Application no: **3/2024/0201**

Address: **21 Abbots Croft Whalley BB7 9RR**

Proposal: **Proposed single-storey extensions to front, side and rear.**

The Local Highway Authority have viewed the plans and highway related documents and have the following comments to make:

S.J. Bialecki
Drawing no 6007
Scale 1:100 1:200 1:50
Proposed Single Storey Extension At Abbots Croft Whalley

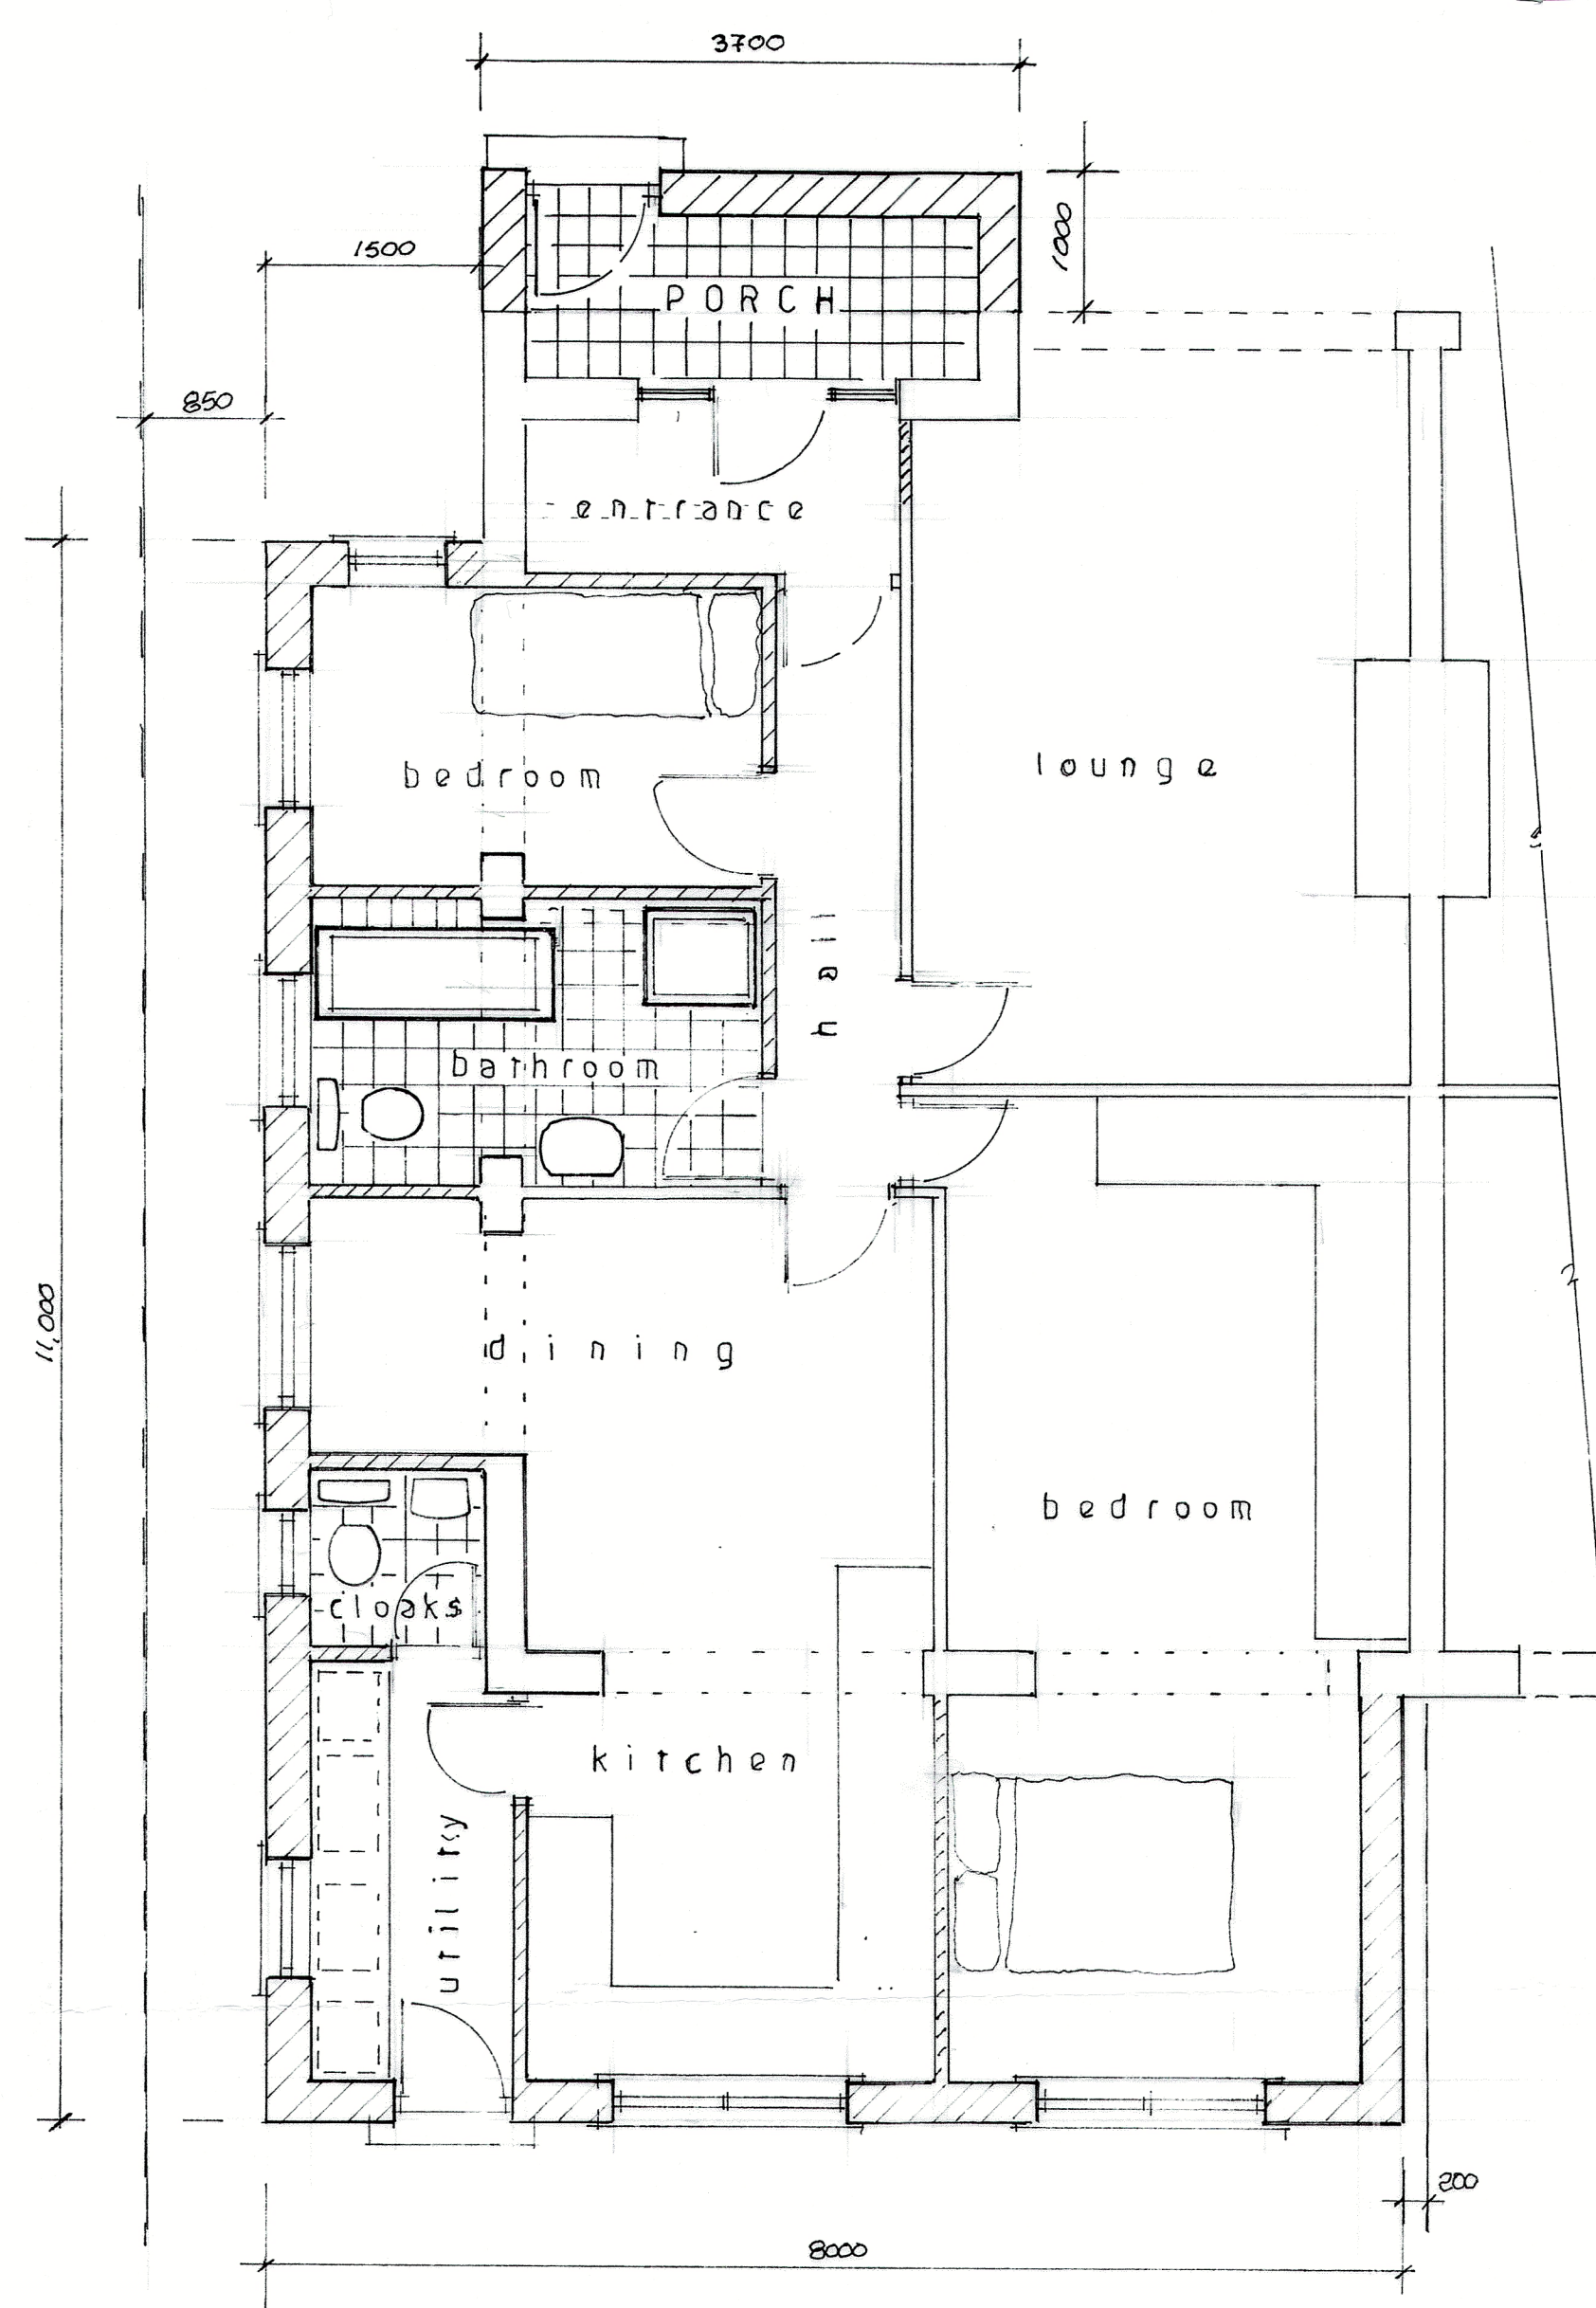
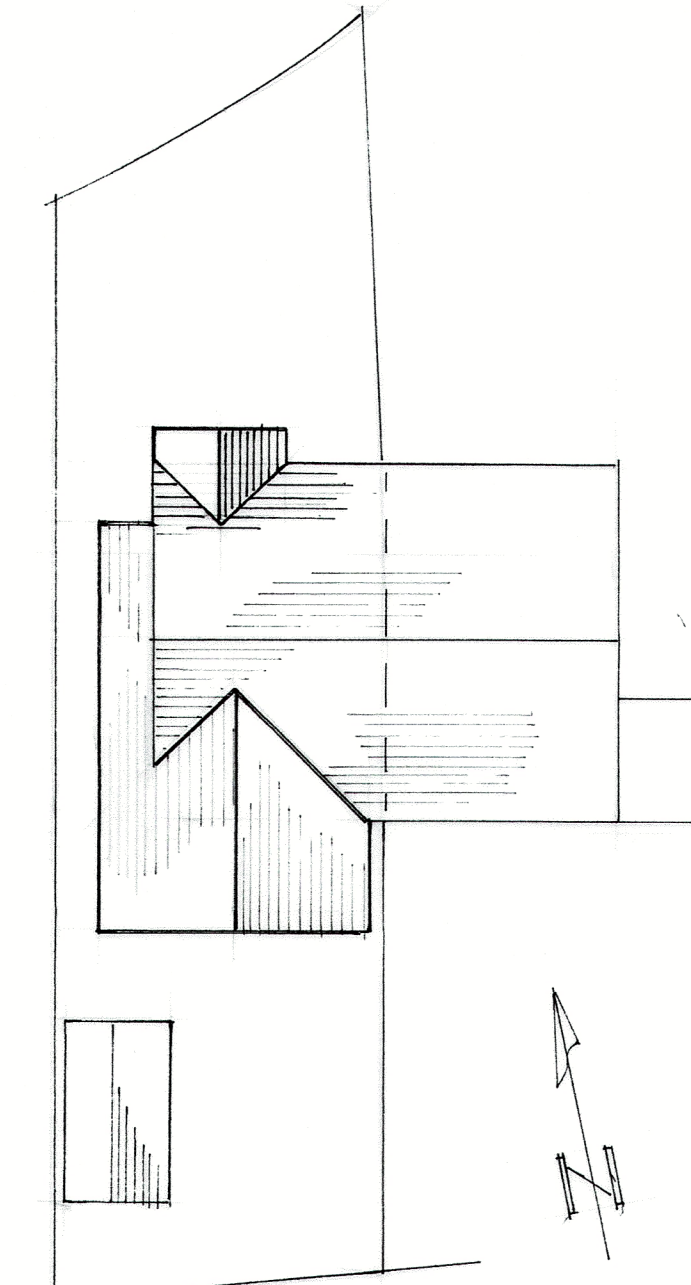
The LHA have reviewed SJ Bialecki drawing number 6007 and are aware that the parking arrangements at the site will change following the side extension to the dwelling. Currently,

the dwelling can provide 2 car parking spaces for the 2-bed dwelling, with the two spaces being provided in tandem on the driveway.

However, following the side extension it's unlikely that the driveway can provide 2 spaces in tandem. Therefore, to ensure that the dwelling can continue to provide 2 car parking spaces for the proposed 2 bed dwelling, a parking plan is required.

Should the dwelling not be able to provide 2 spaces, as expected, the existing dropped kerb will need to be extended by a minimum of 2.4m. This may lead to the streetlight and the gully on the adopted highway needing to be relocated but this can be addressed as part of the Section 171 Agreement which is required for the dropped kerb application.

The LHA require a revised plan showing that the dwelling can continue to provide 2 car parking spaces. Should the existing dropped kerb and the driveway need to be extended to incorporate a second space, this should be stated on the drawing.
